Recommendation Report for Planning Permission for Works or Extension to a Dwelling

REF NO: EP/51/26/HH

LOCATION: Dene Cottage
156 Sea Road
East Preston
BN16 1PB

PROPOSAL: Proposed single storey front extension / porch and new pitched roof over existing garage.

Drawing Number: AR-204-02

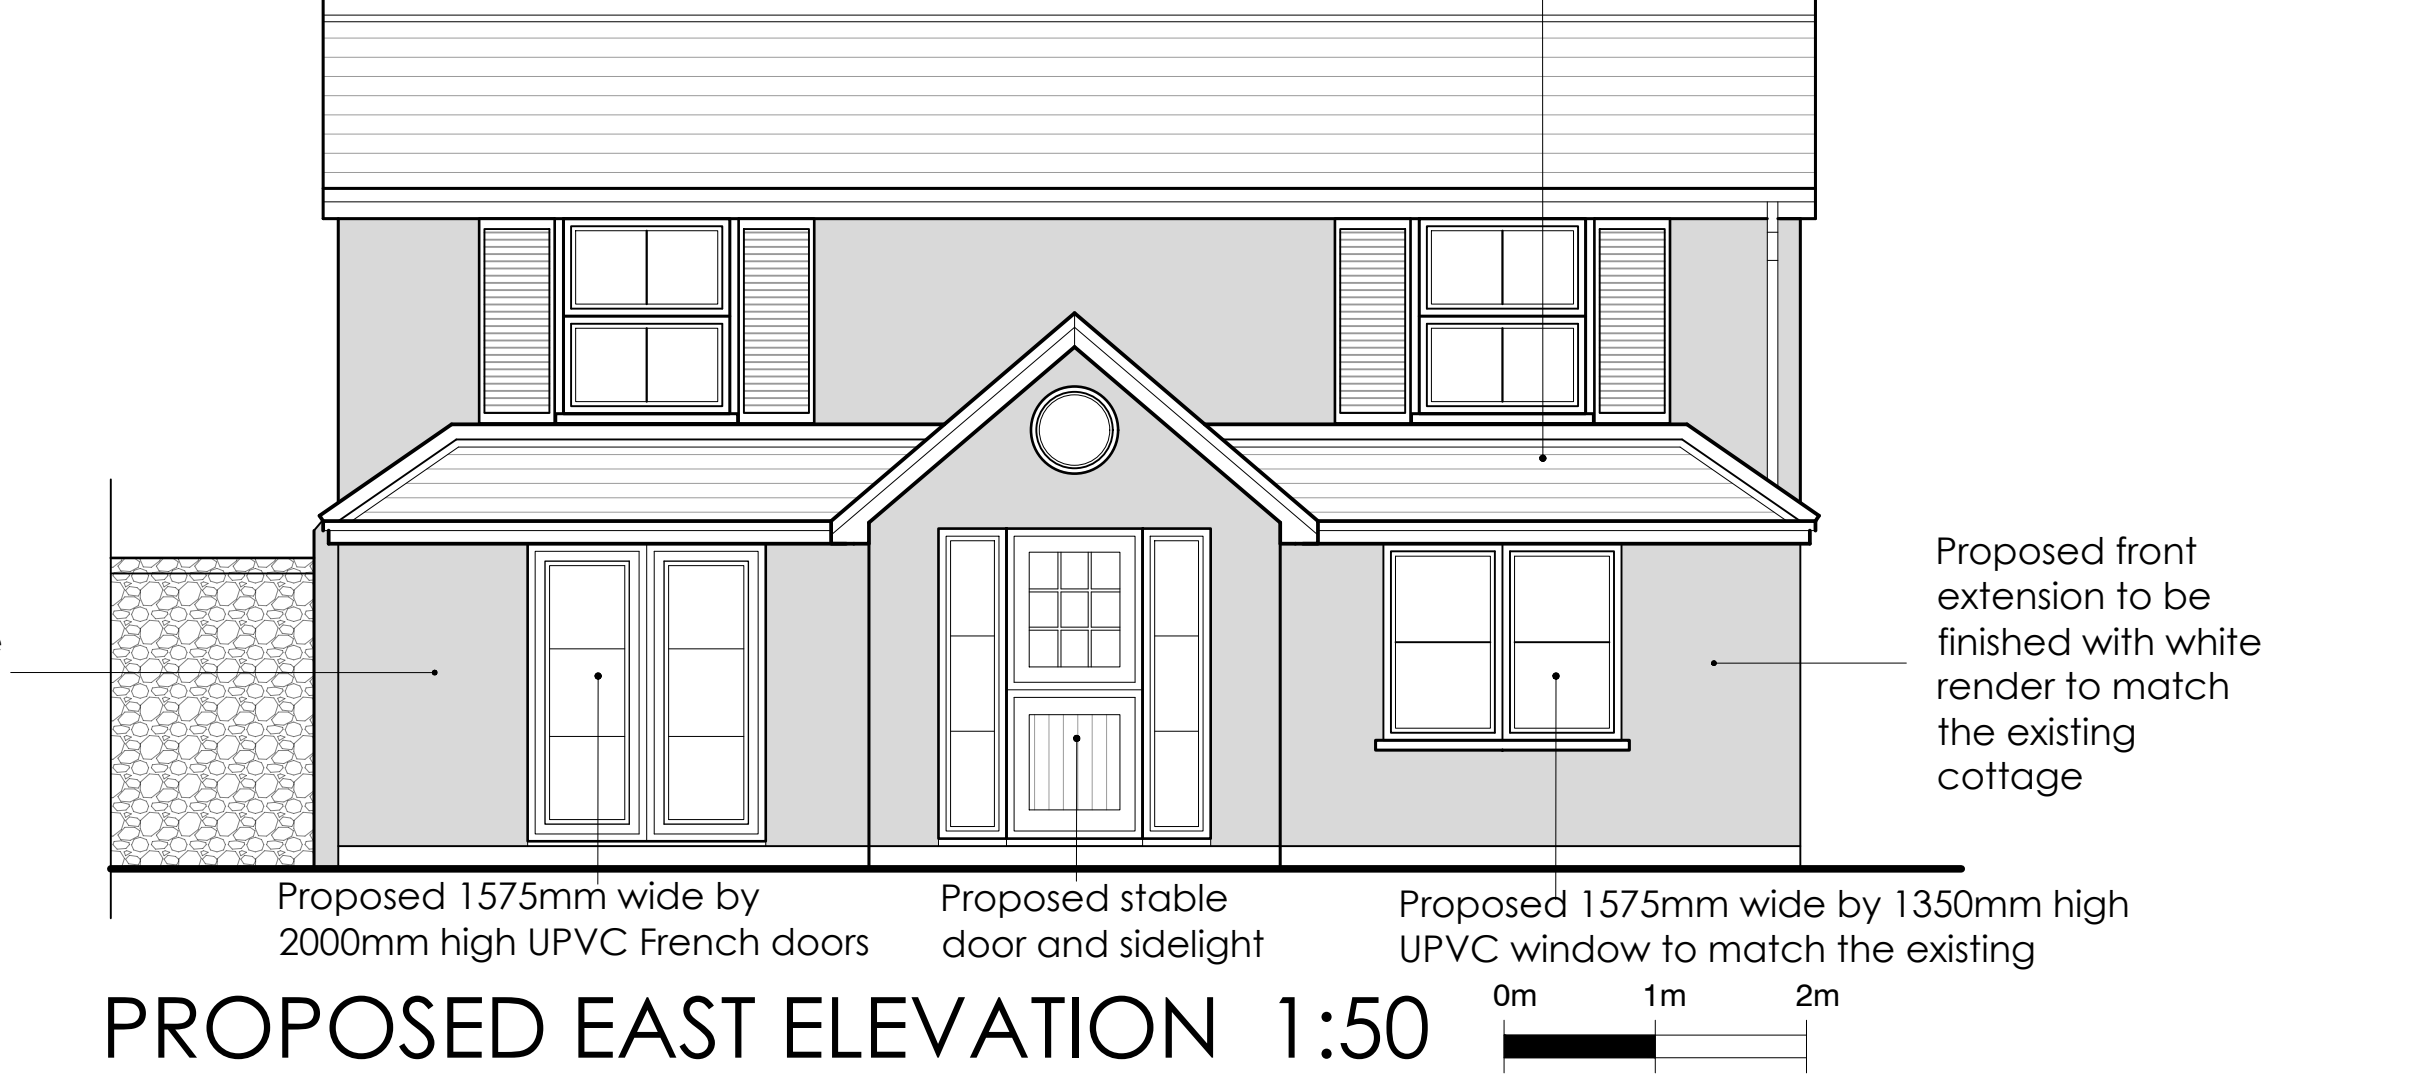
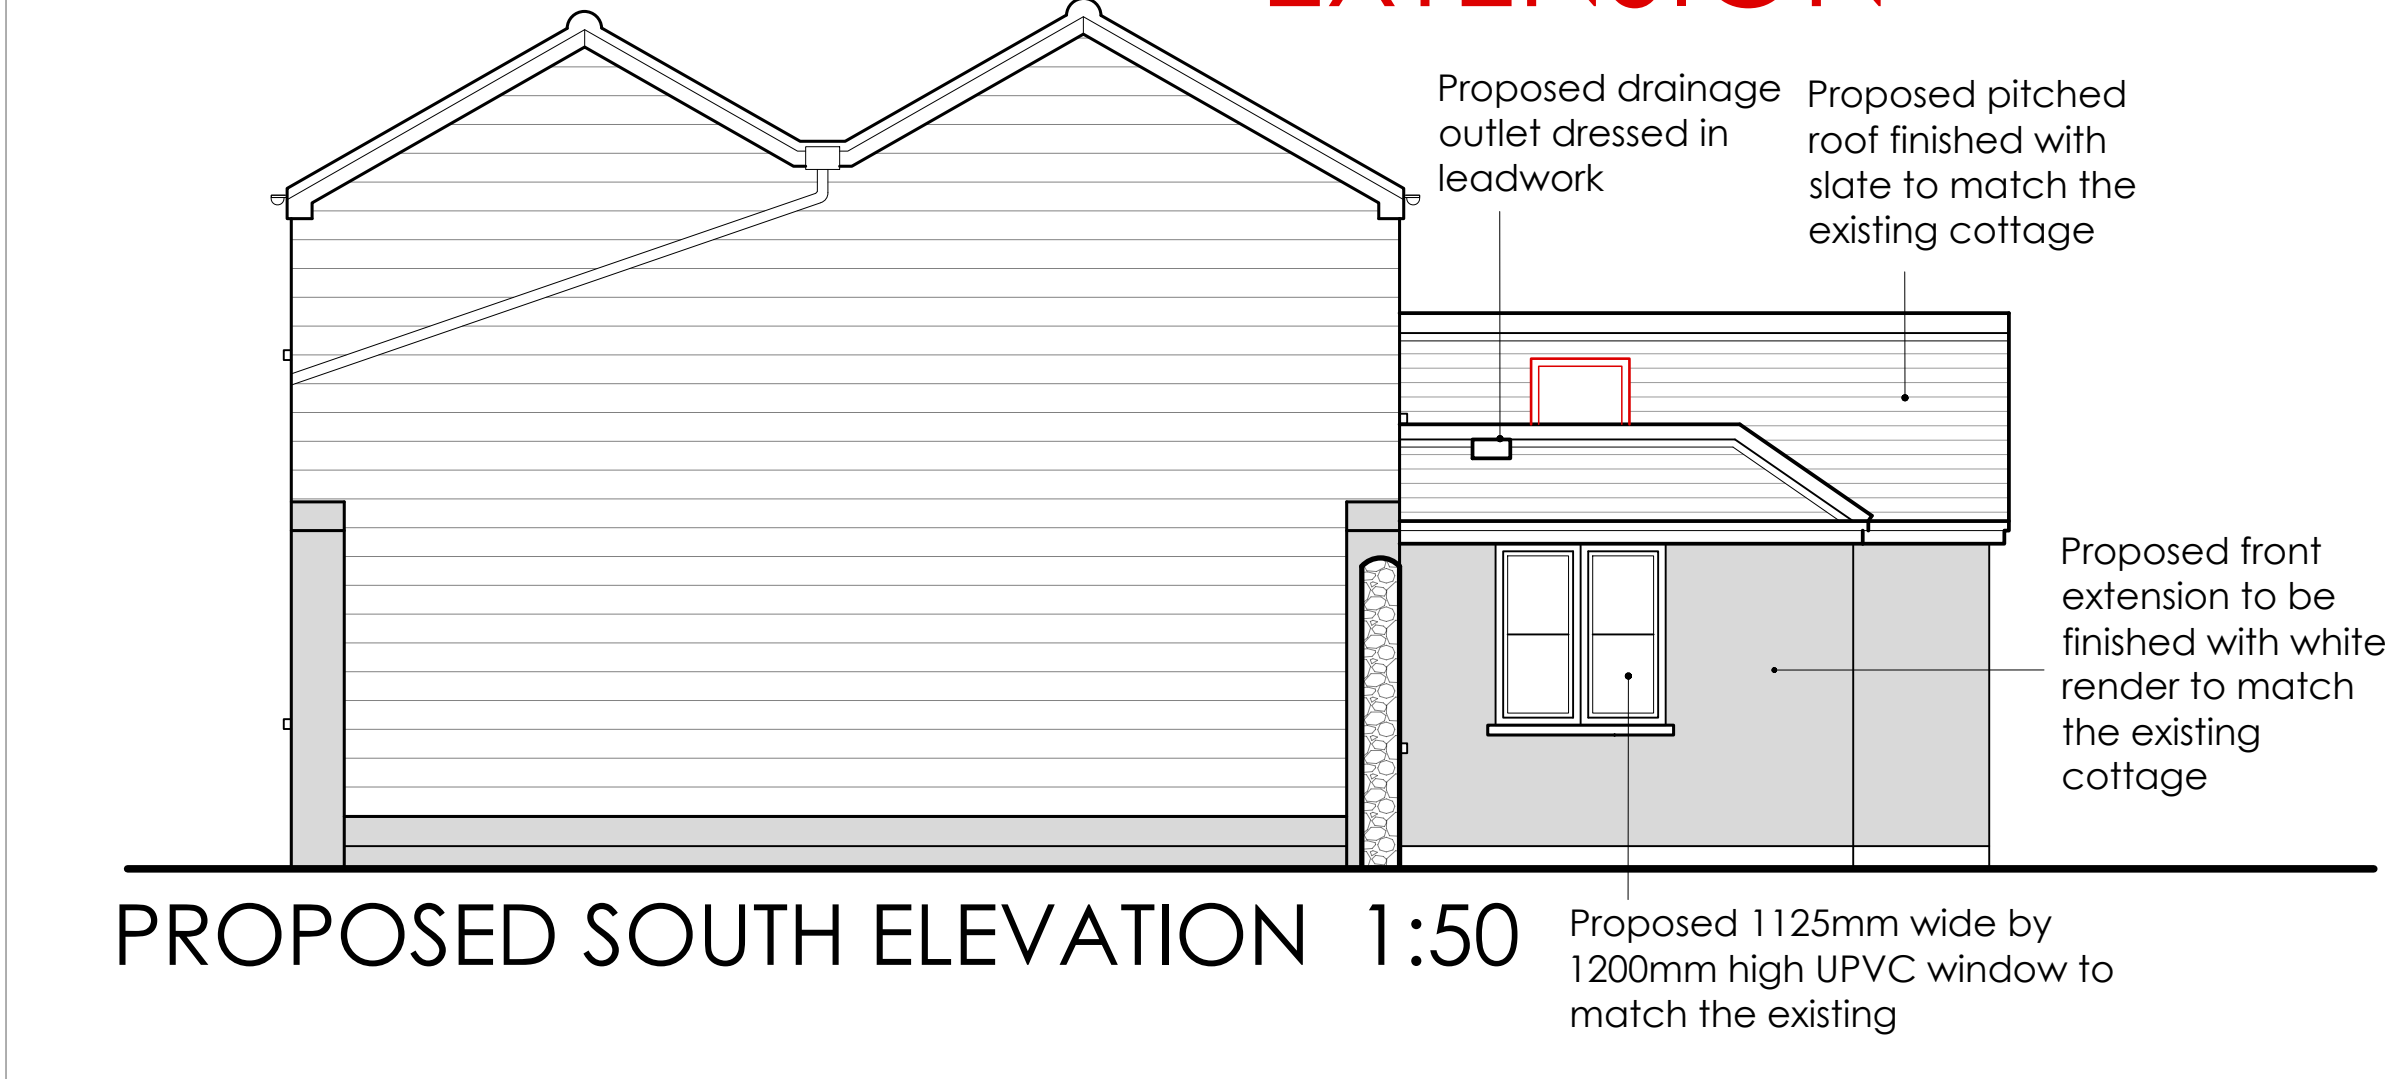
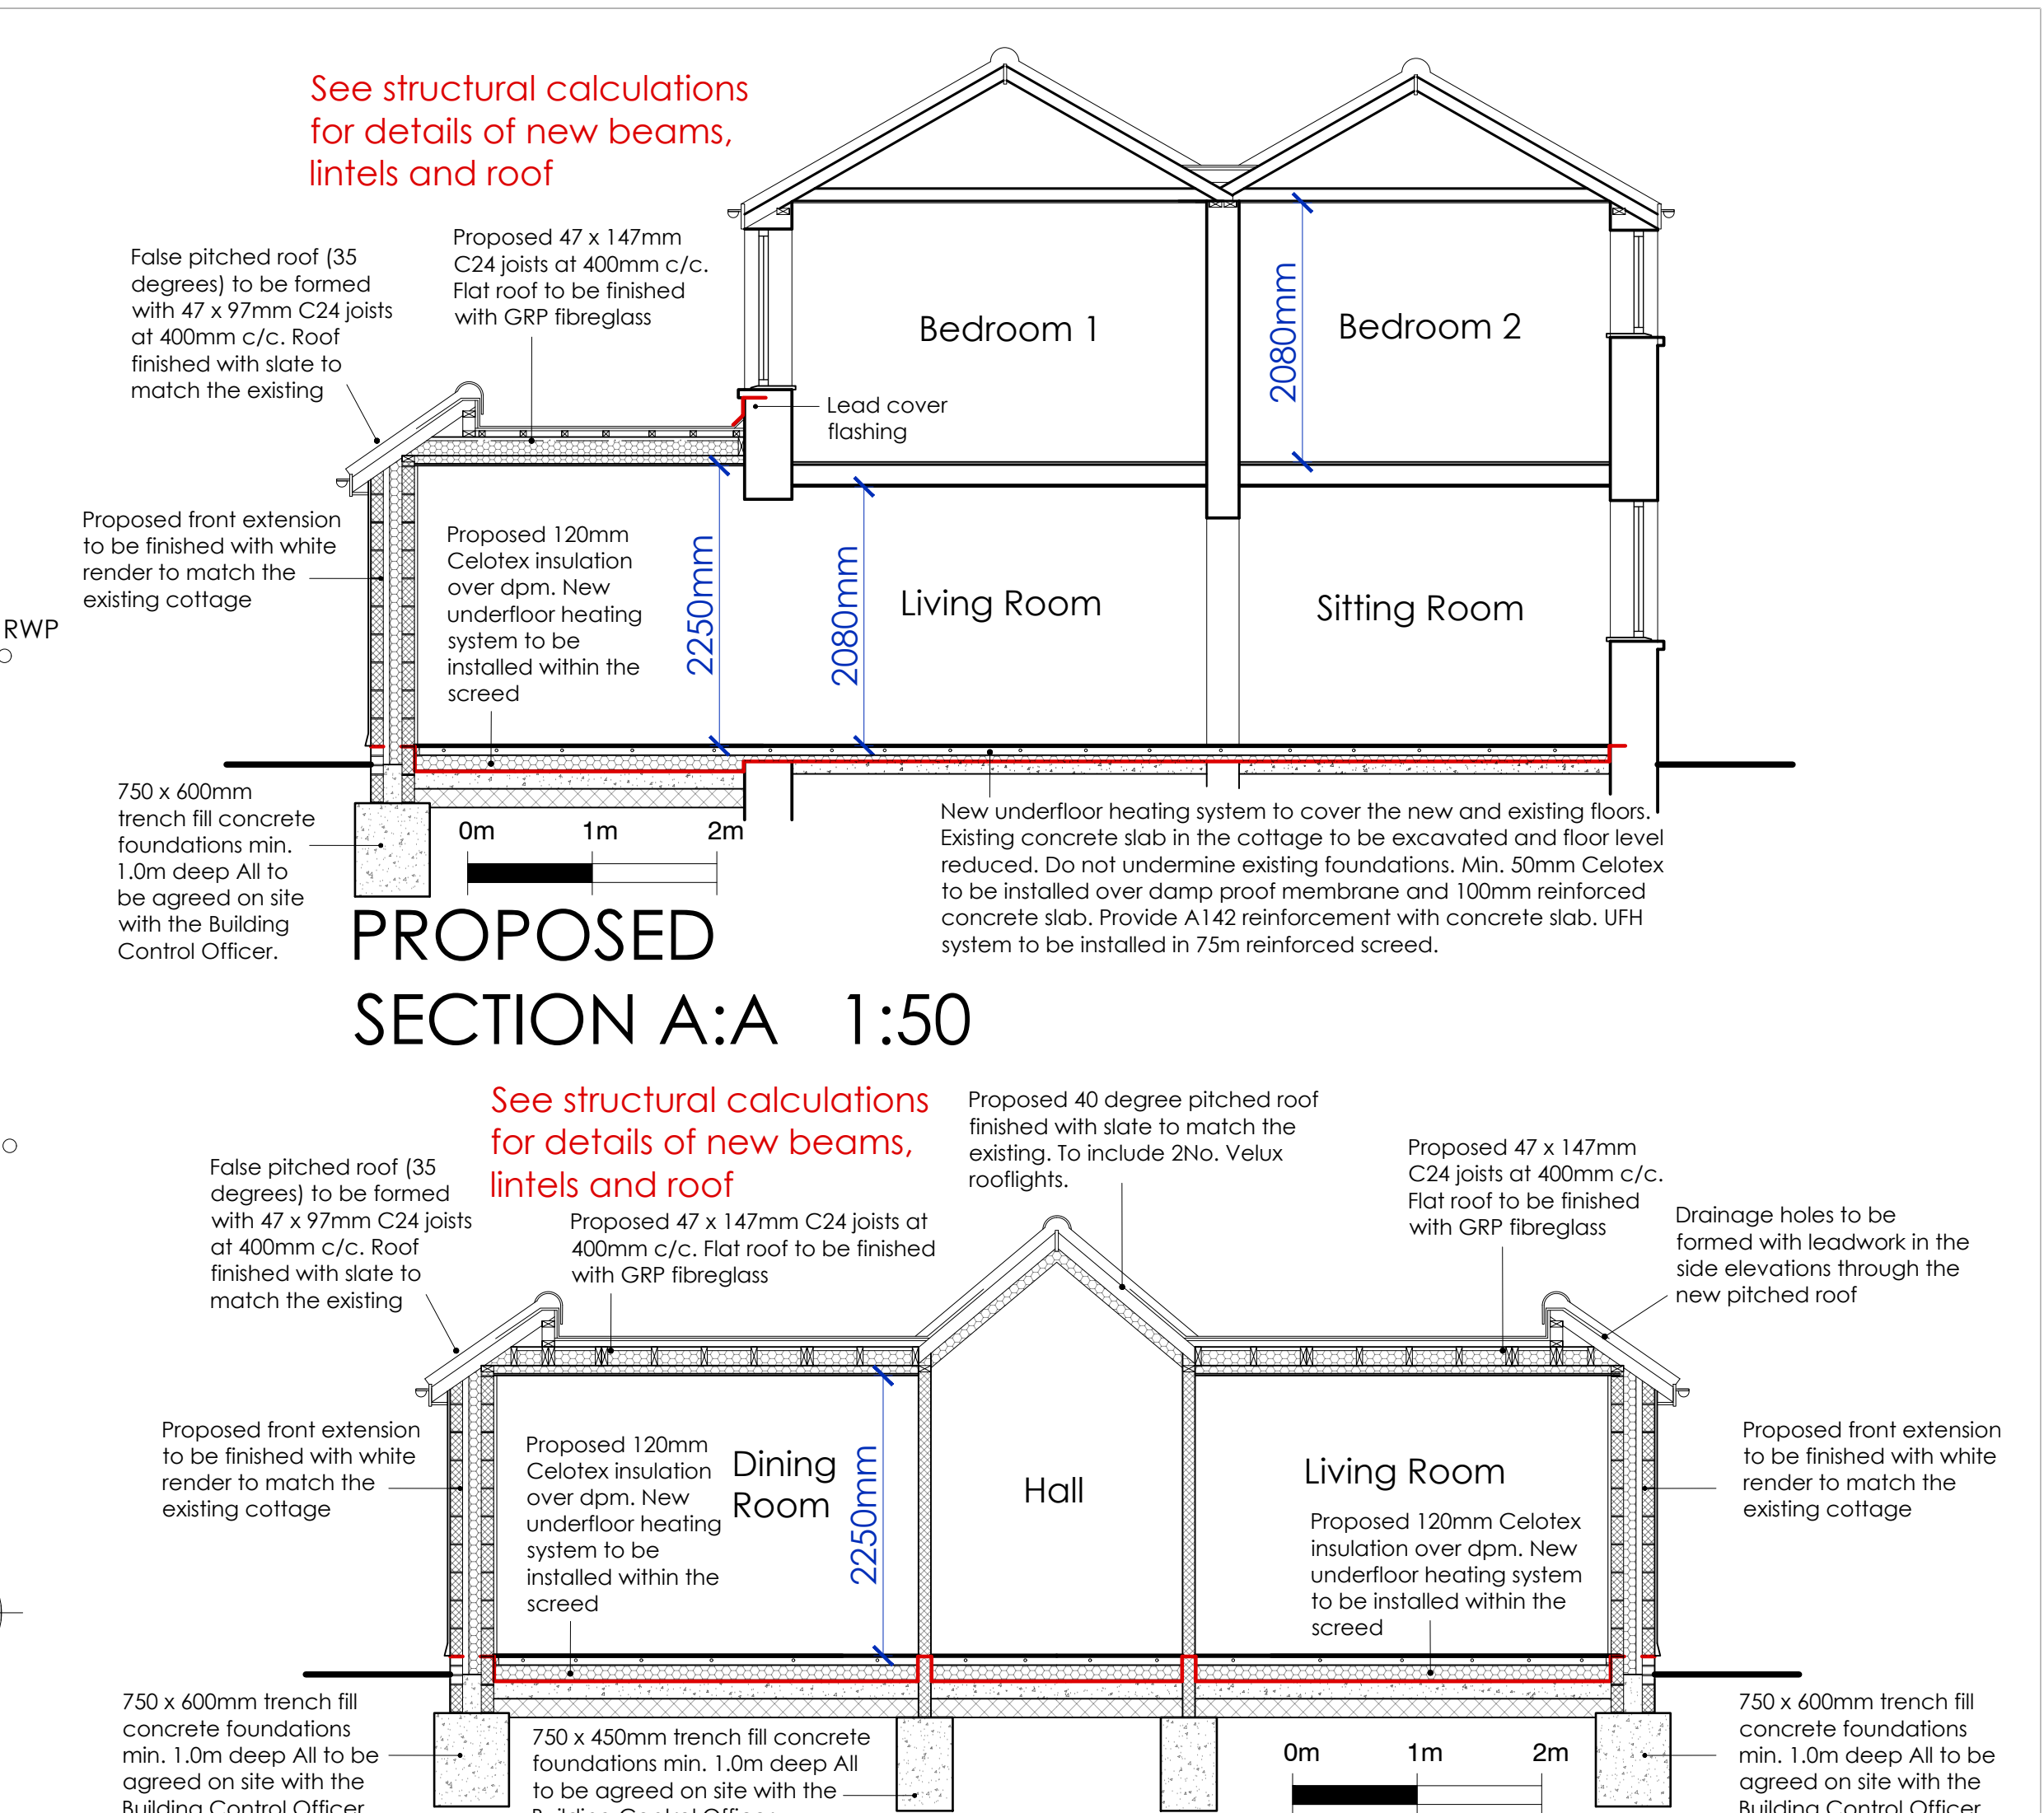
The extension would span the width of the host dwelling (10m) and would include a single storey projection (porch) with a pitched roof at a height of 3.7m, set in the centre of the extension with a depth of 3.8m (0.8m further than the remainder of the front extension). The remainder of the extension would have a crown roof, at a height of 3m, incorporating roof lights on each of the flat roofs either side of the central projection. Two roof lights would also be incorporated in the pitched roof slopes of the central projection.

The Arun Design Guide (ADG) states front / porch extensions should not exceed 1.5m in depth or be the full width of the dwelling. The proposal conflicts with these principles, however, given the size of the front amenity area, resultant distance from the highway (32m) and existing boundary treatment / screening, the proposal would not result in harm to visual amenity or the street scene.

The extension would be finished with white render, appropriate for the coastal setting and reflective of the existing render. Slate would be used on the roof slopes, to match the existing dwelling. The proposed material palette is appropriate and would ensure the extension would be congruous and subservient, in accordance with Arun Local Plan policies D DM1 and D DM4.

Owing to the proposed setting of the extension at the front of the dwelling and its single storey form, with fenestration proposed on the east (front) and south elevation only, any views available would be of the front and side gardens only, resulting in no harm by of overlooking.

While the extension does span the width of the dwelling, it would be set in by 3.8m from the northern boundary with the block of flats to the north (152 Sea Road). Considering this, as well as existing built form and boundary treatment, the proposal would not result in any overbearing or overshadowing impacts.

The extension would abut the site boundary with The Well House, to the south. Considering the existing boundary treatment (2m high flint wall), the outbuilding in the northeast corner of the garden at The Well House and its favourable siting to the south of the application site, there would be no harm by way of overbearing and overshadowing impacts.
